CITY OF ALBUQUERQUE

August 19, 2016

Re: Drainage Control Ordinance (14-5-2-1) and NPDES CGP Violations for Erosion and Sediment Control and Pollution – La Luz Del Oeste Unit 4

**SILT FENCE**  
NTS

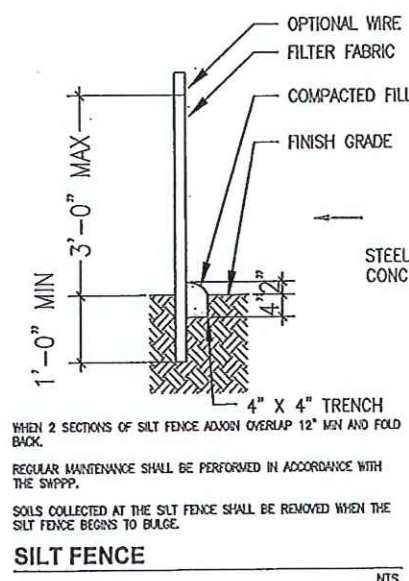
1. Missing silt fence along Dellyne Ave. Sediment was observed leaving the site.
2. The construction entrance needs maintenance.
3. The sediment BMP across road to Mill Rd needs improvement. Sediment observed in Mill Rd.
4. In addition to the repeat violations listed above, numerous instances of cement pollution were observed. See photos with descriptions.

1. Install silt fence along project boundary along Dellyne Rd and remove sediment from the sidewalk.
2. Improve the construction entrance to Erosion Control Plan specifications.
3. Install the series of wattles across the road to Mill Rd. per the Erosion Control Plan.
4. Remove cement pollution material and have an acceptable concrete wash-out on site.
